From: Mundy, Ben - Oxfordshire County Council <Ben.Mundy@Oxfordshire.gov.uk>
Sent: 09 August 2022 10:35
To: DC Support; Dale Jones
Cc: Transport CDC Minor; Cllr Nigel Simpson
Subject: 22/01683/F Unit 7, Oxford Technology Park, Technology Drive, Kidlington, OX5 1GN

Planning Application: 22/01683/F

Location: Unit 7, Oxford Technology Park, Technology Drive, Kidlington, OX5 1GN

Description: Development within Use Classes E (g) (i), and/or (ii), and/or (iii), and/or B2 and/or B8 and Associated Works including Access and Parking

content : BUILDING 7
PROPOSED CYCLE LOCATIONS

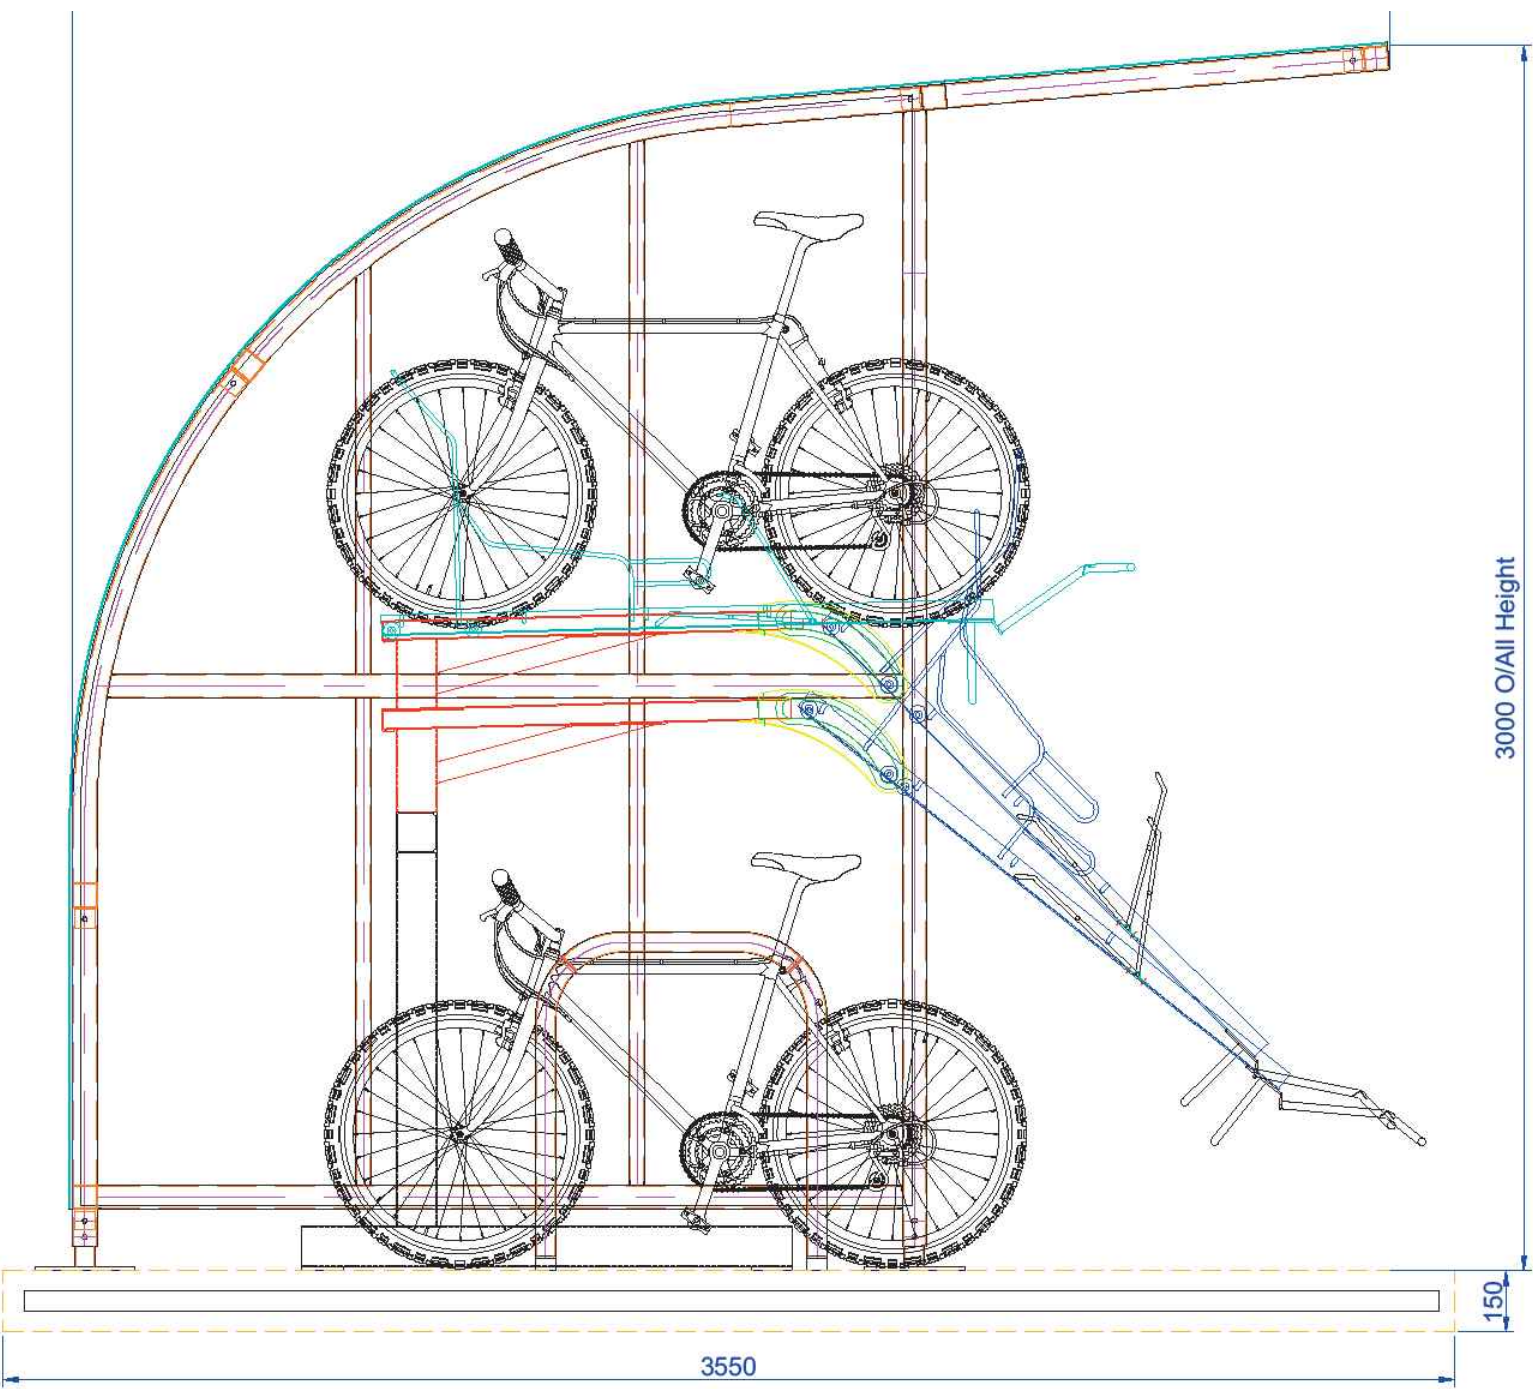
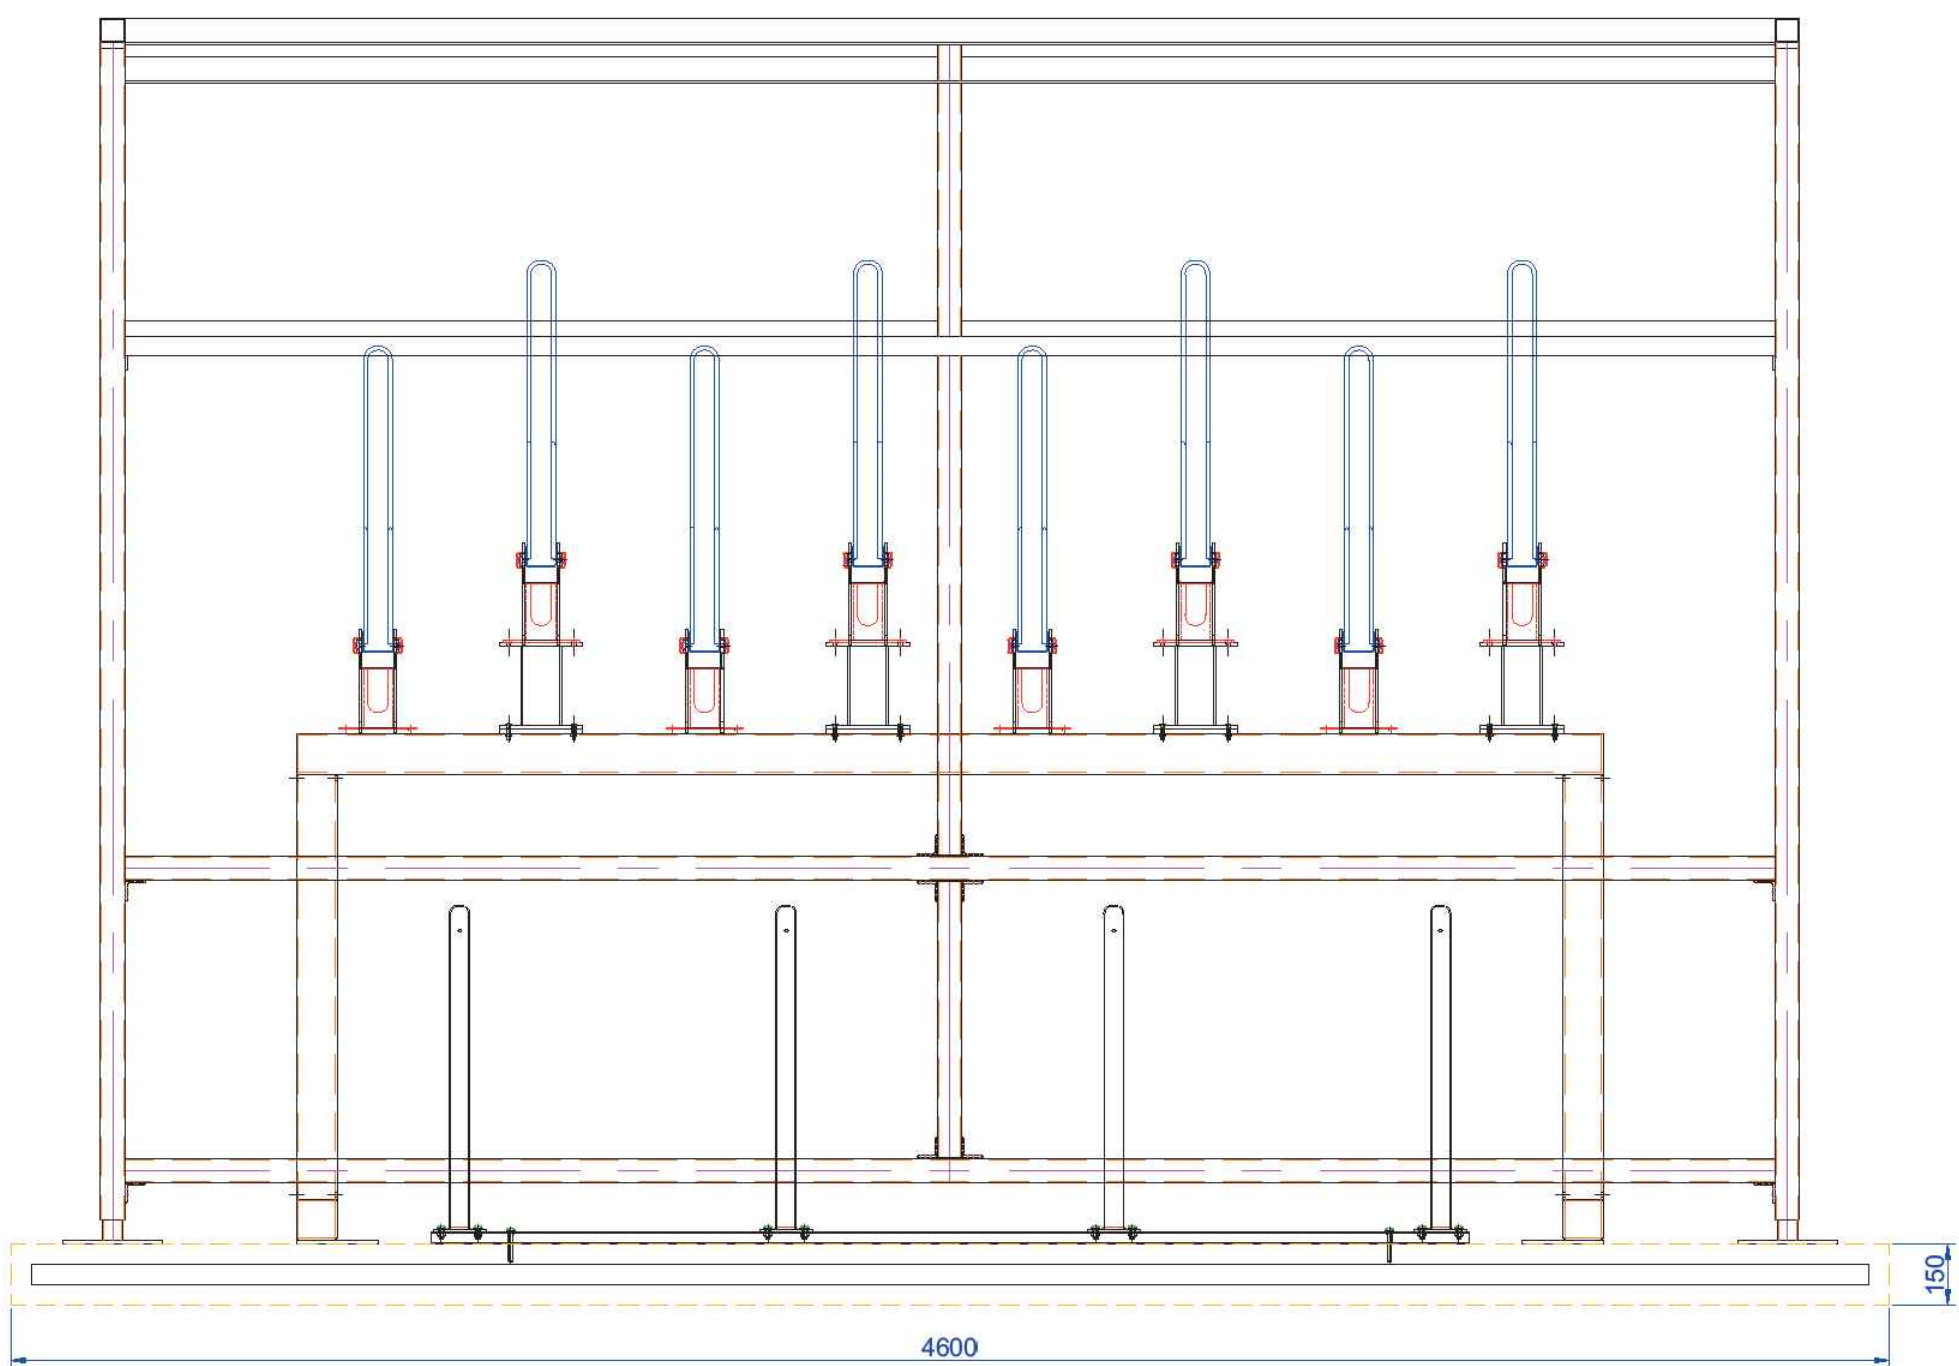
Cycle Parking: Cycle parking should be single tiered if there is adequate space, this is to ensure that is accessible as possible.
